RE: **U-Haul at West Bluff**
Atrisco Drive NW
Grading Plan (Stamp Date 1/30/17) and Drainage Report (Stamp Date 12/5/16)
Hydrology File: H11D059

Based upon the information provided in your submittal received on 2/1/17, the Grading Plan and Drainage Report are approved for Building Permit and Grading Permit.

RE: U-Haul at West Bluff Grading & Drainage (File: H11D059)

Please find the following responses addressing staff comments from correspondence dated January 17, 2017 listed below:

<b>WEST BLUFF BUSINESS CENTER</b>	DRAWN BY DY
	<b>GRADING AND DRAINAGE PLAN</b>	DATE 1/30/17
	<b>TERRA WEST, LLC</b> 5571 MIDWAY PARK PLACE NE ALBUQUERQUE, NM 87109 (505) 858-3100 www.tierrawestllc.com	2016061-GRB
		SHEET # <b>GR-1</b>
RONALD R. BOHANNAN P.E. #7868		JOB # 2016061

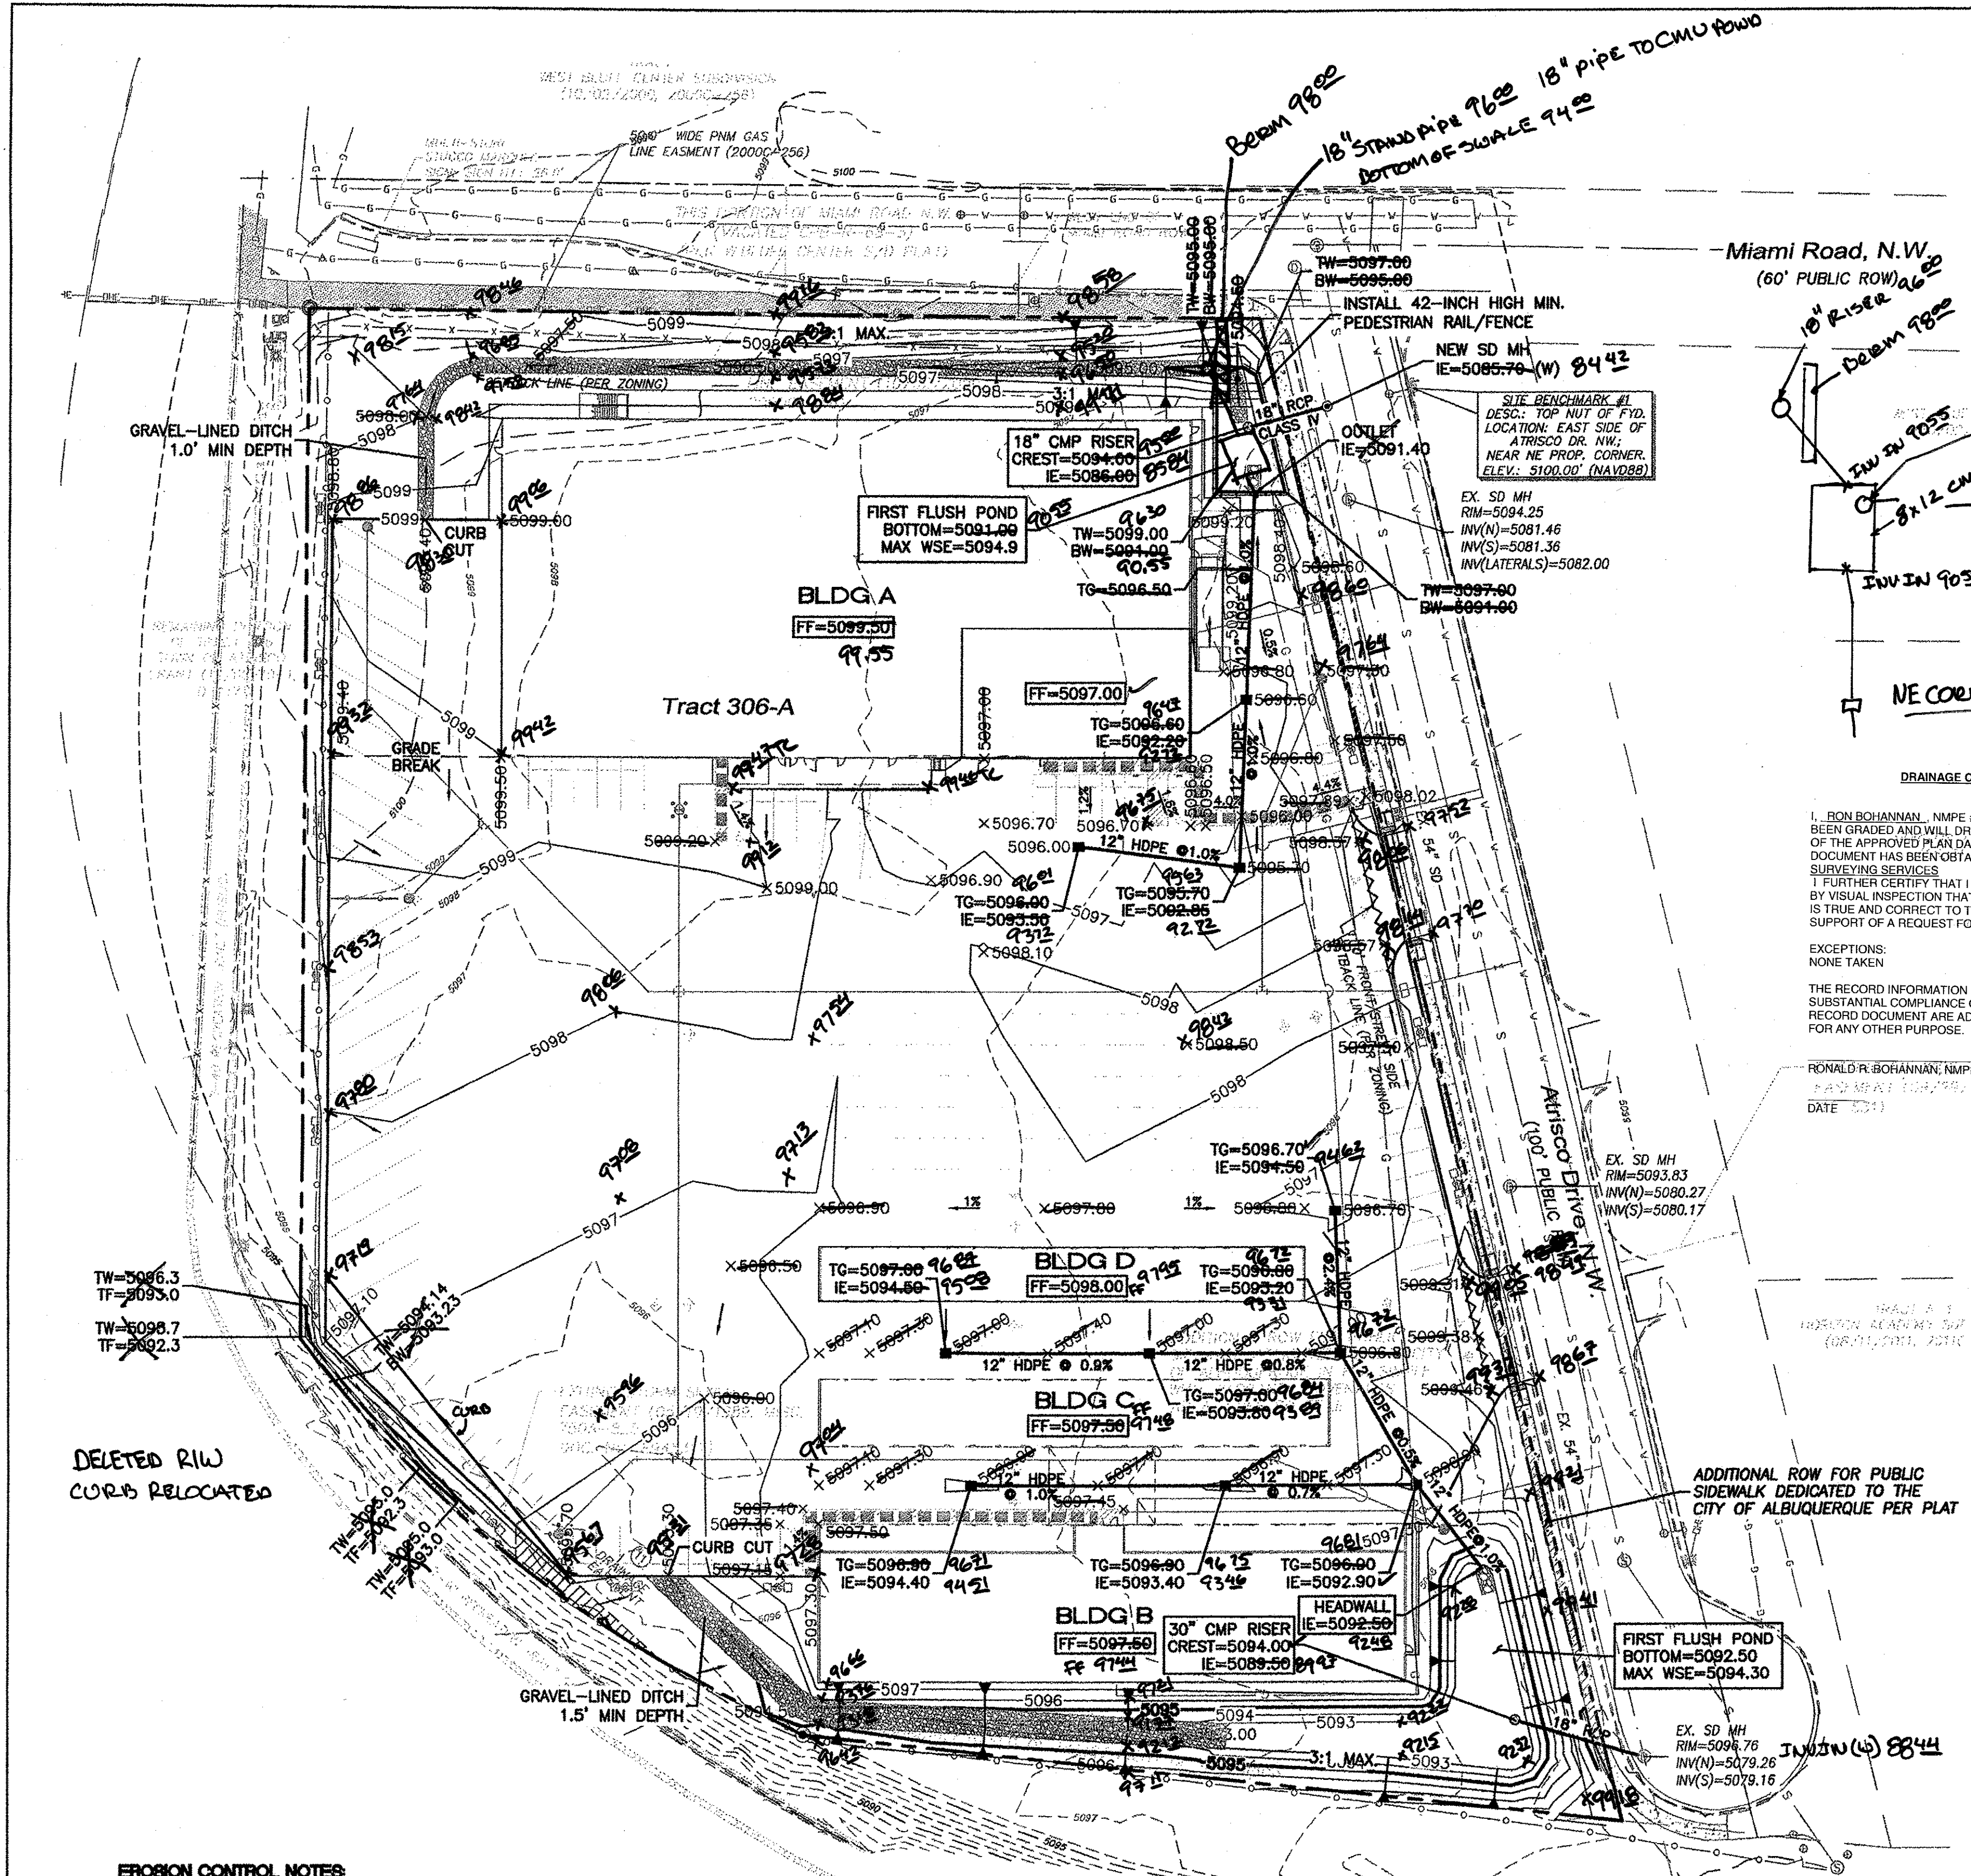
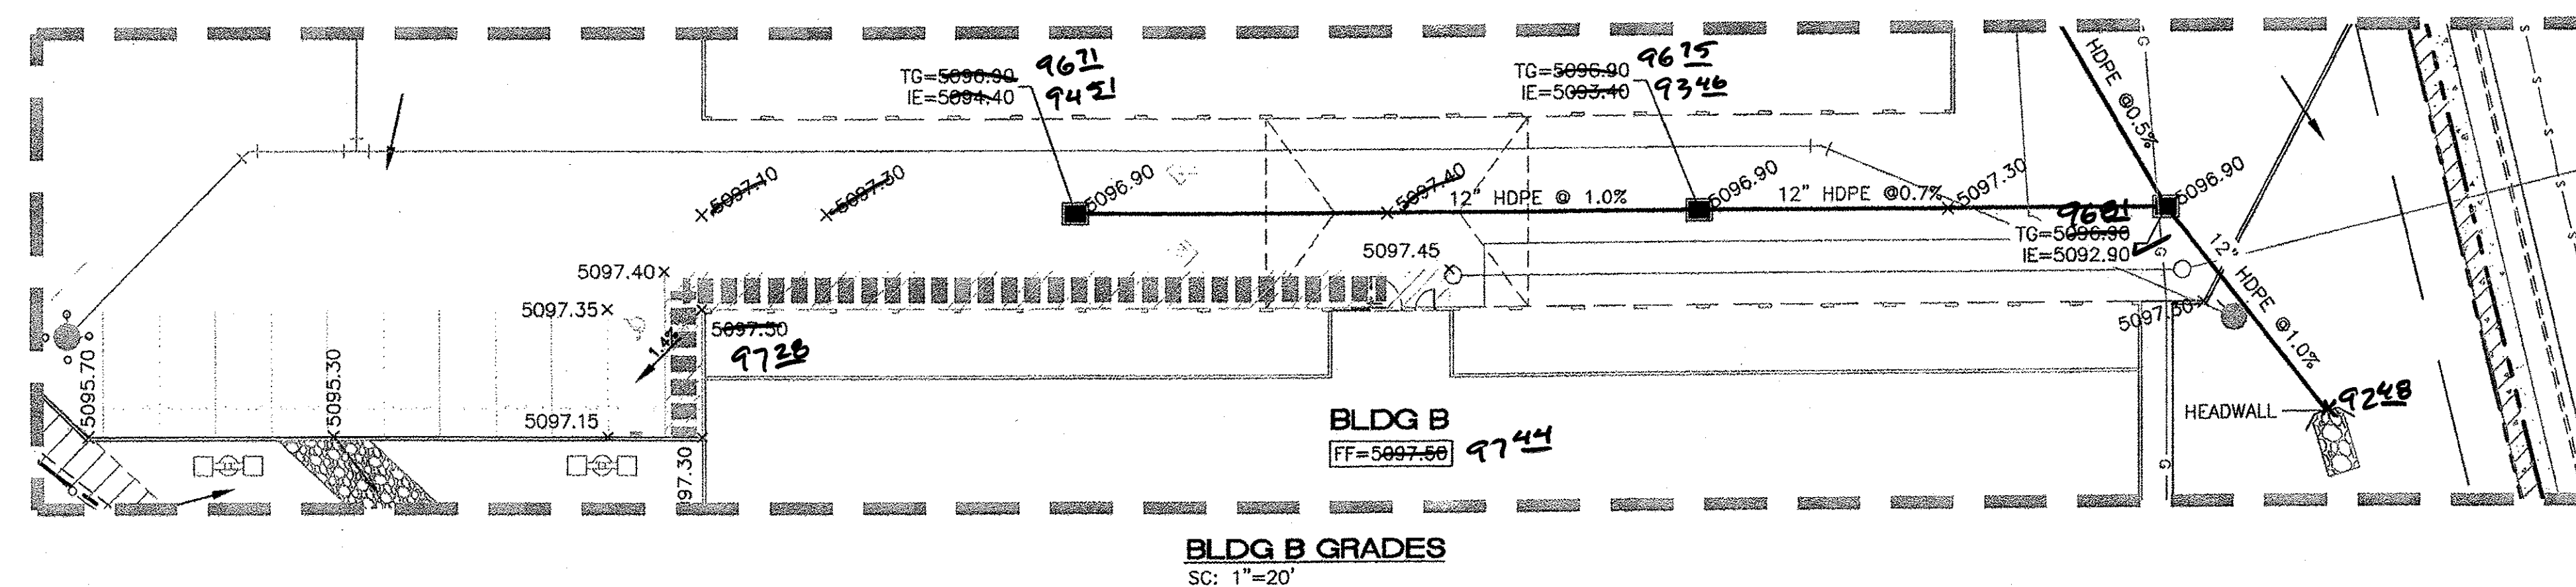
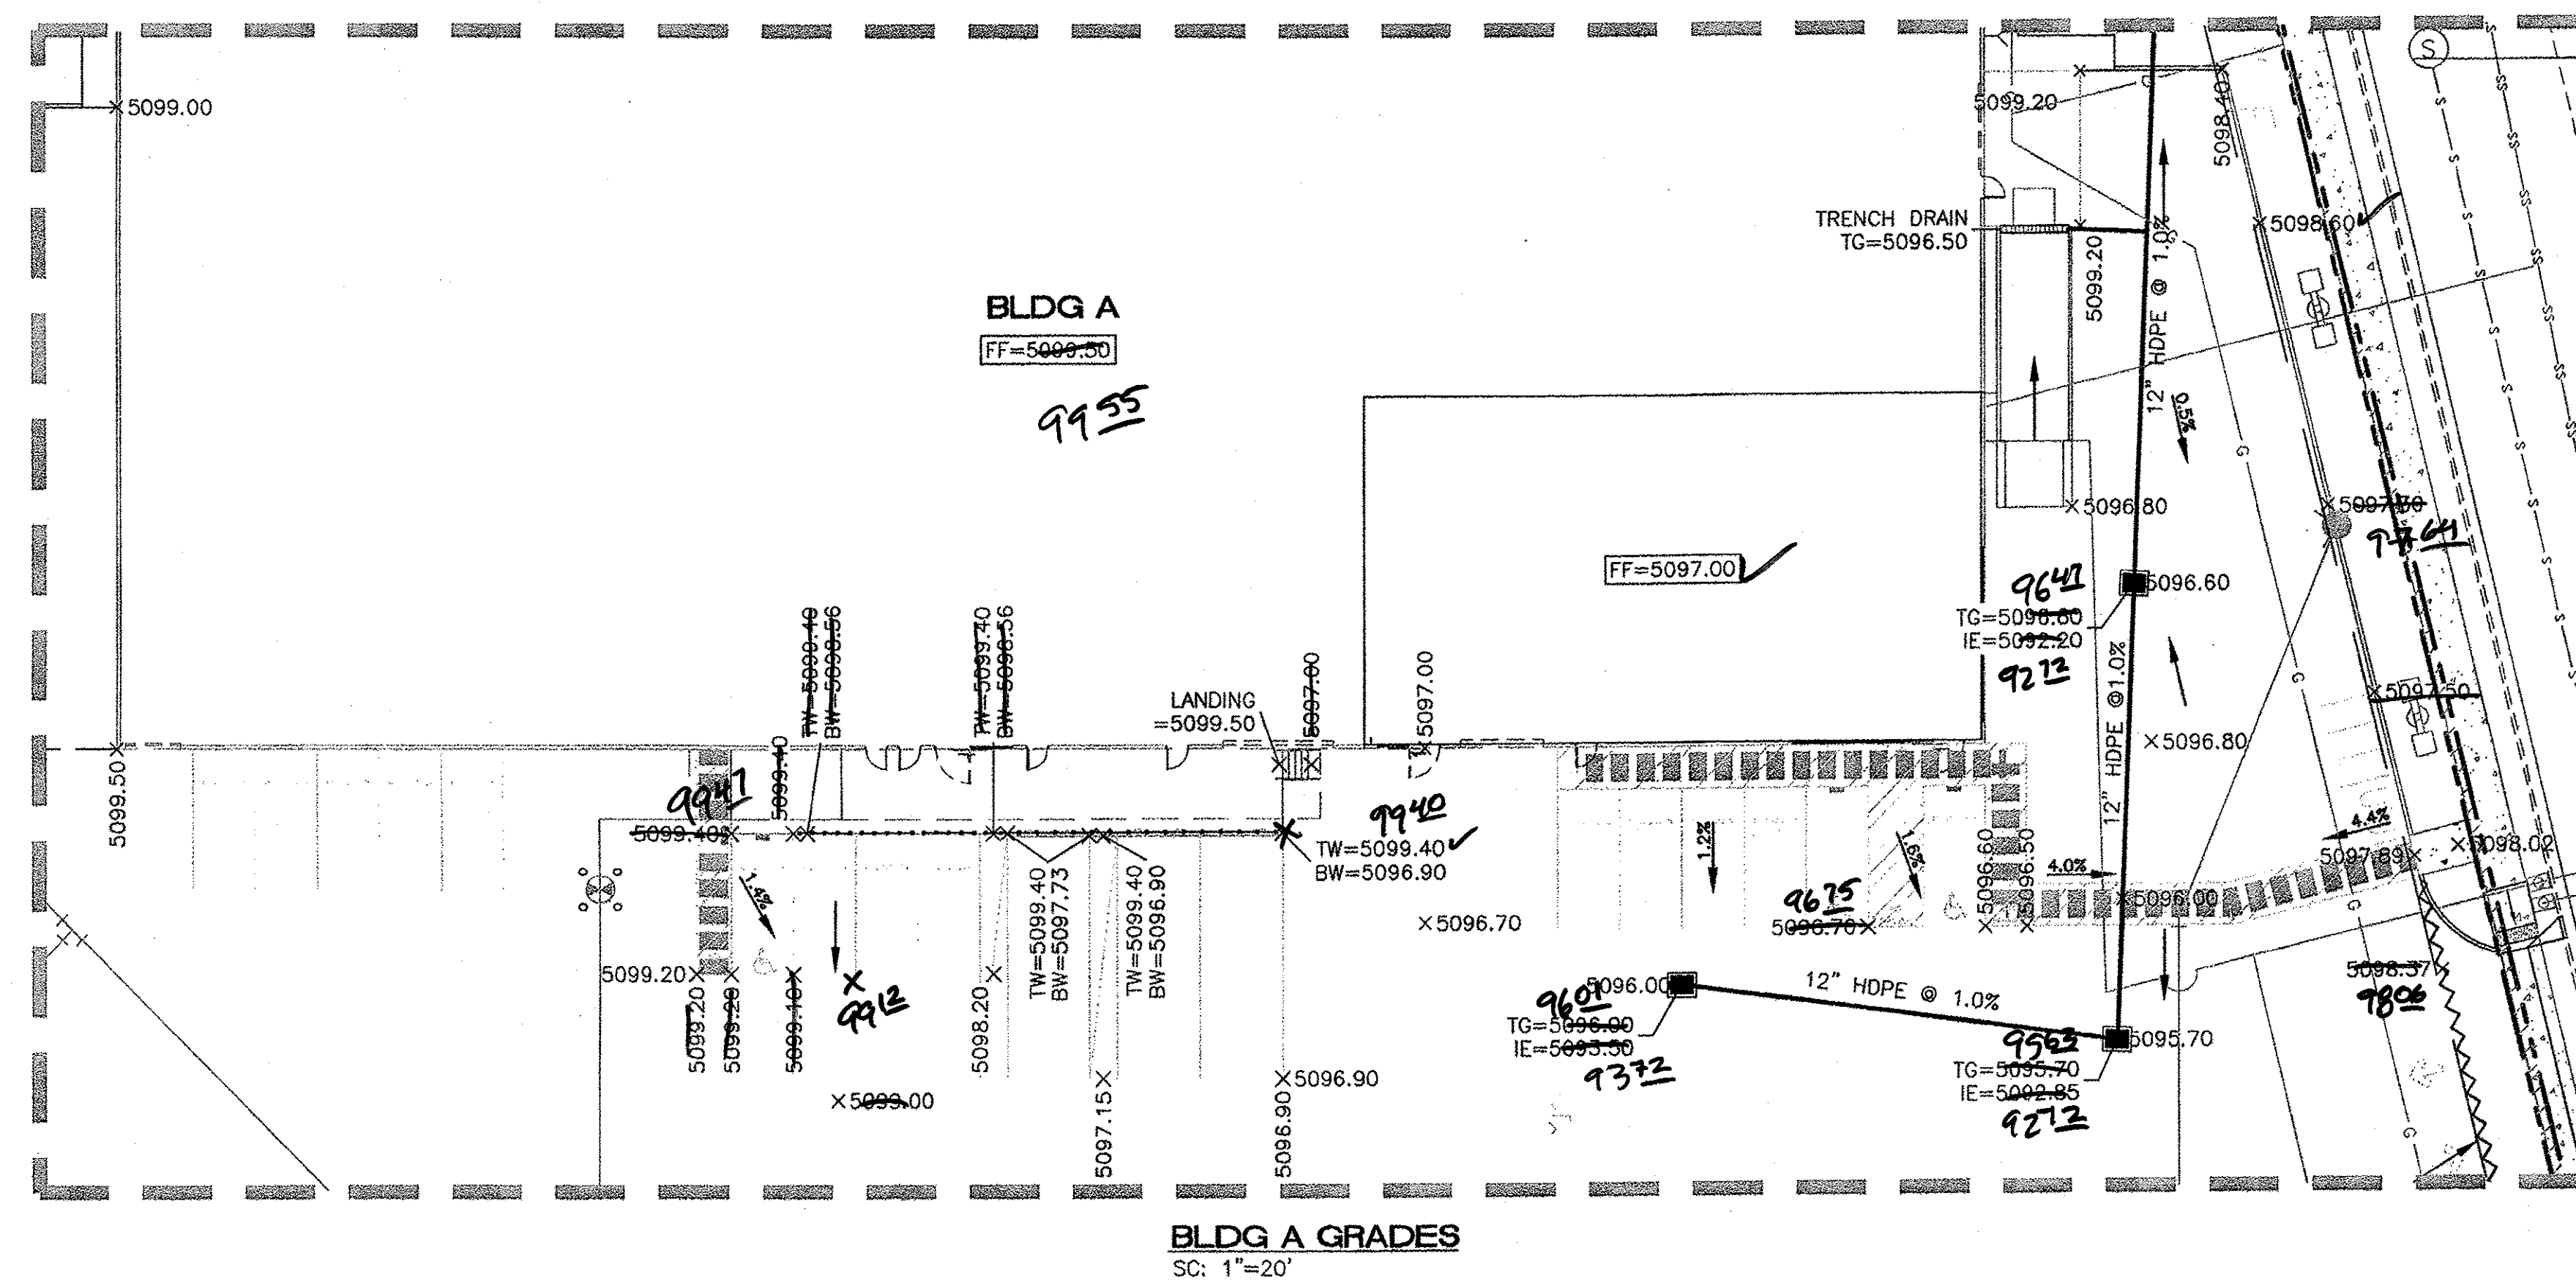
1. The North detention pond appears to be bounded by a CMU retaining wall as high as 8 feet in some places. This will need to be enclosed with a fence at least 42 inches high.

2. Call out Class IV RCP for the north detention pond outfall pipe under the retaining wall.

4. Project Benchmark and Vertical Datum is missing from the sheets. The Drainage Management Plan addresses the NGVD29 to NAVD88 shift, but sheets need this information as well.

Response: We have updated the plan (Sheet GR-1) to include a pedestrian barrier/fence.

Response: We have revised the plan (Sheet GR-1) to specify Class IV RCP for this section of pipe.

Response: We have updated the plan (Sheet GR-1) with a benchmark elevation in NAVD88.
